**Re: 2-6 Hassall Street, Parramatta – Response to Submissions**

I refer to the Site at 2-6 Hassall Street, Parramatta and the Submissions received from City of Parramatta Council (Council) and Transport for New South Wales (TfNSW), regarding the State Significant Development 9670 for the Western Sydney University Innovation Hub (Proposal).

Sheet Name
BASEMENT
©BLIGHT RAYNER ARCHITECTURE PTY LTD ACN 614335956
Use figured dimensions only. Do not scale. Check all dimensions on site prior to fabrication or setout. These designs, drawings and specifications are copyright and must not be used, kept or copied by any means without permission.

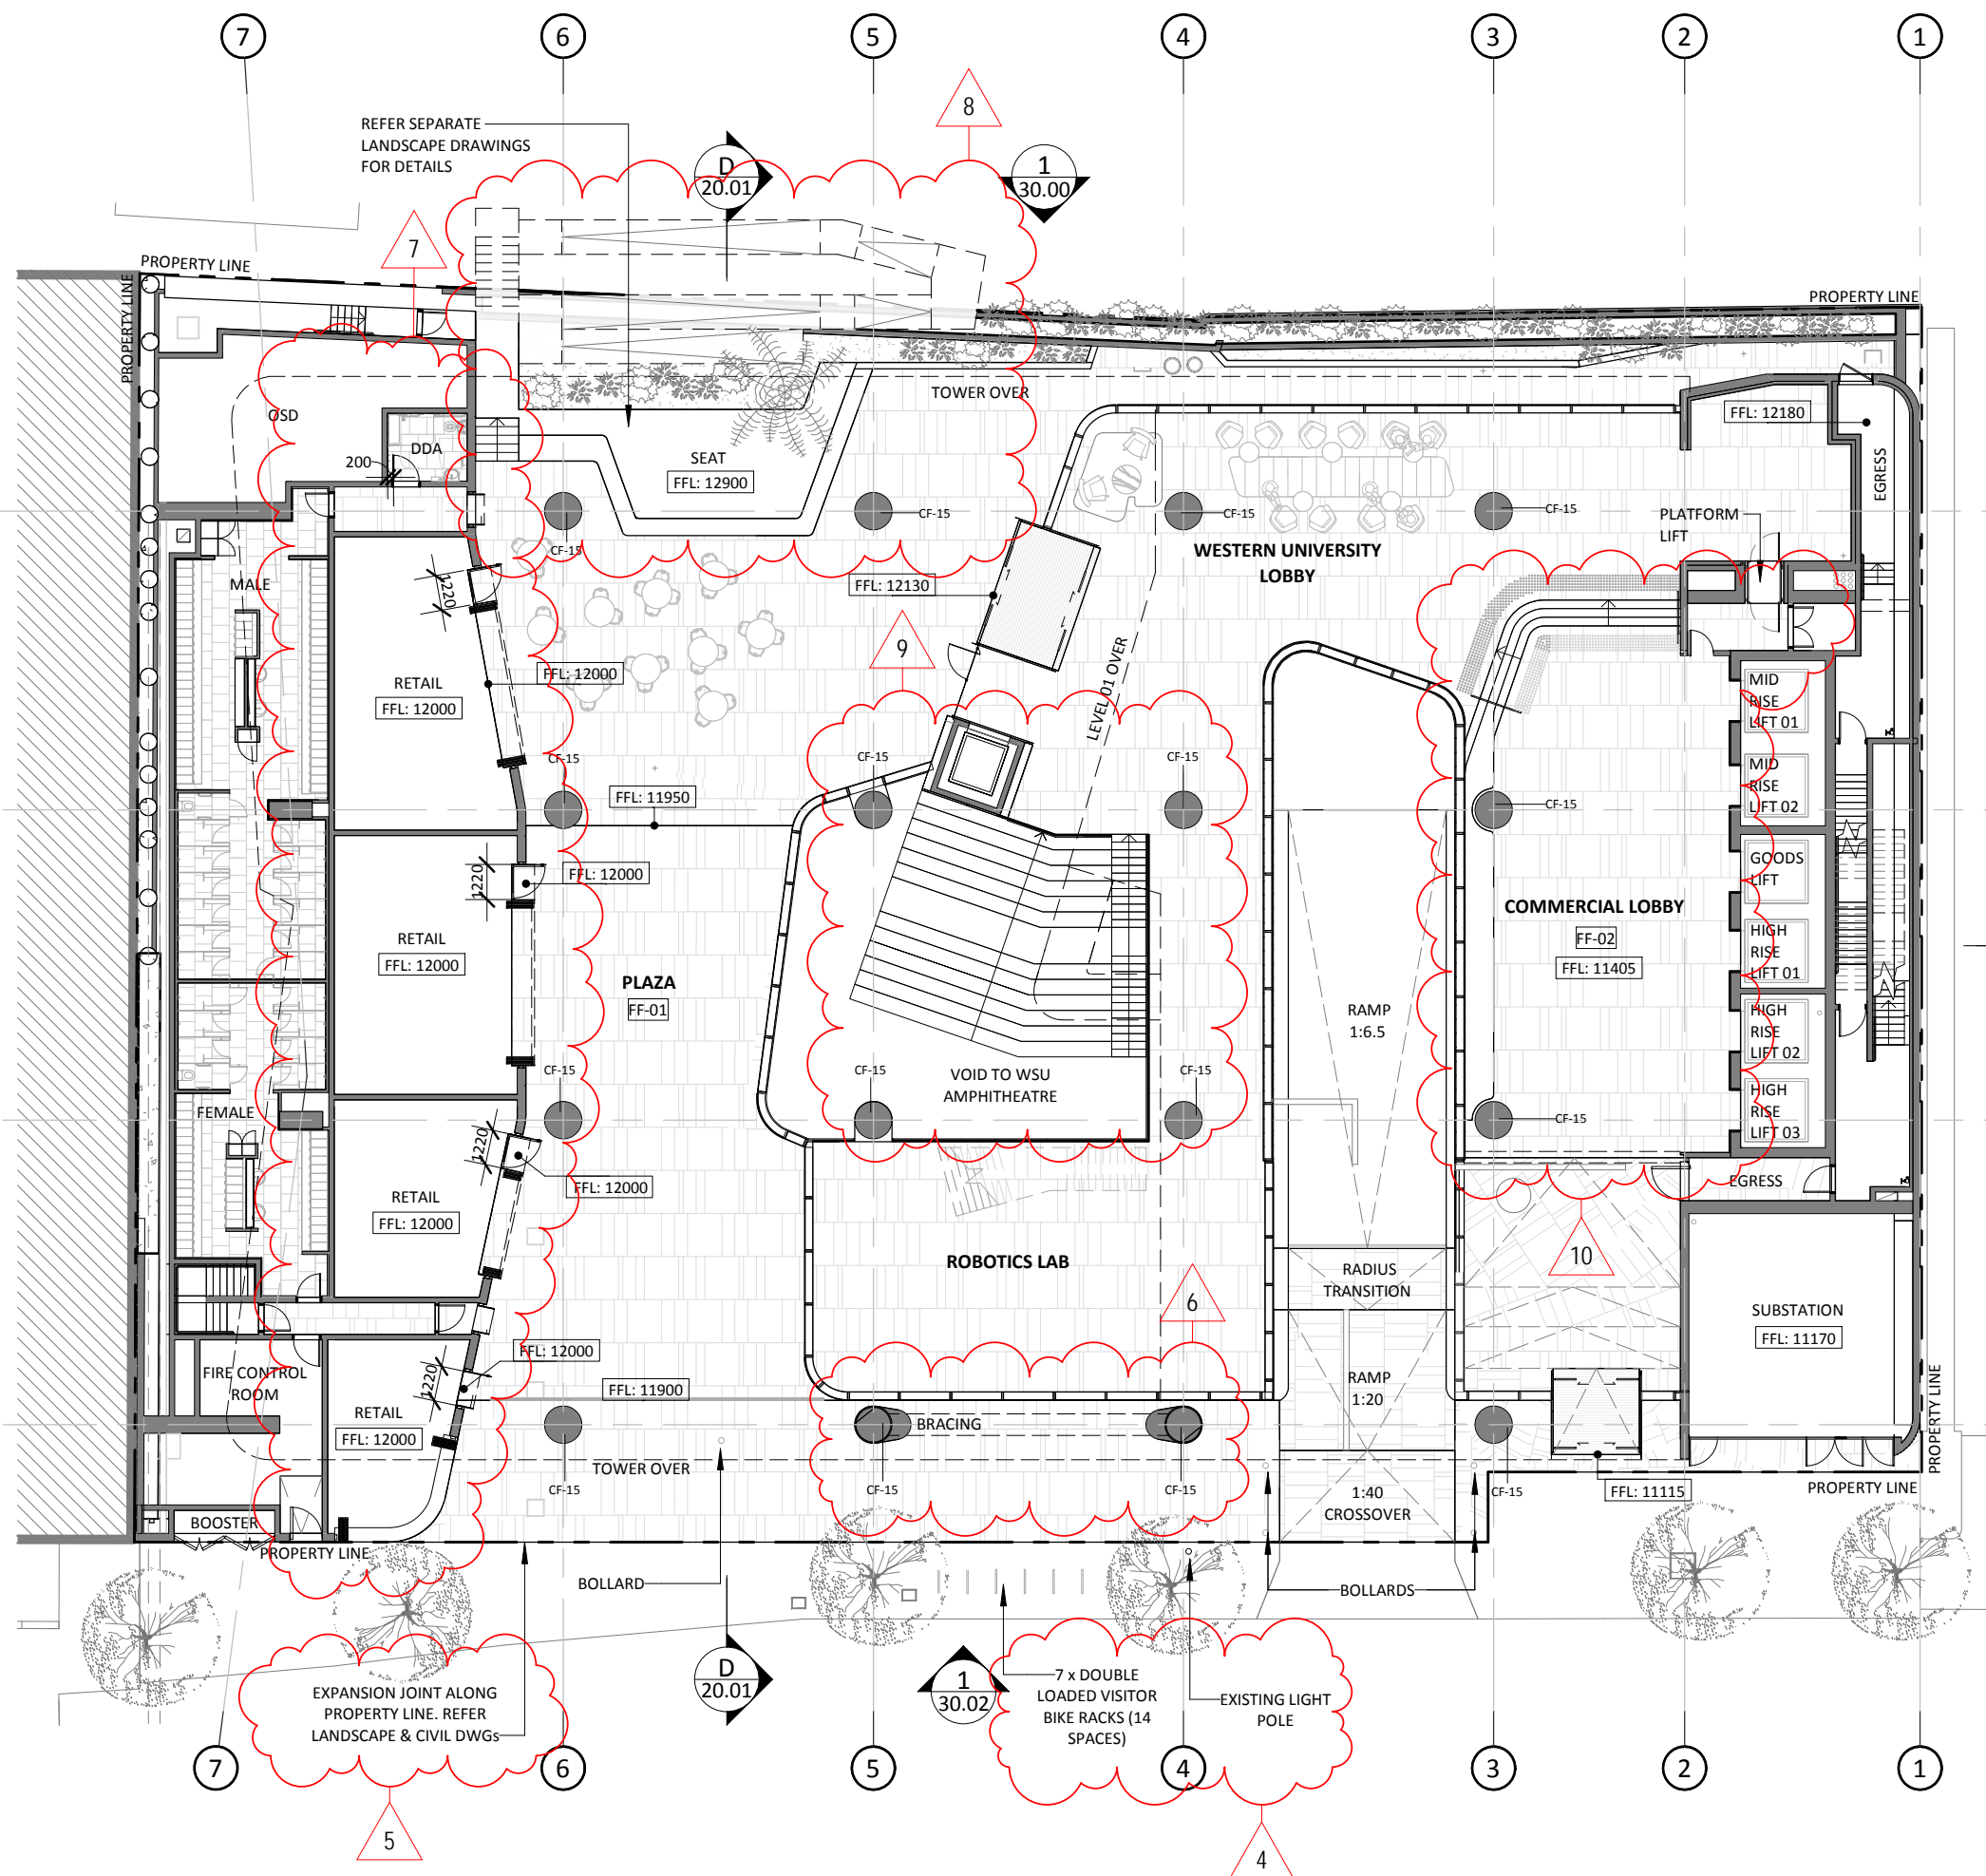
*Must ensure that adequate sight distance in accordance with AS2890.1-2004 is achieved at the basement entry driveway.*

Noting that Hassall Street is a one-way street in a westbound direction, adequate sight distances can be achieved at the basement entry, in accordance with AS2890.1. This would be confirmed at Construction Certificate stage of development and is expected to form a Condition of Consent.
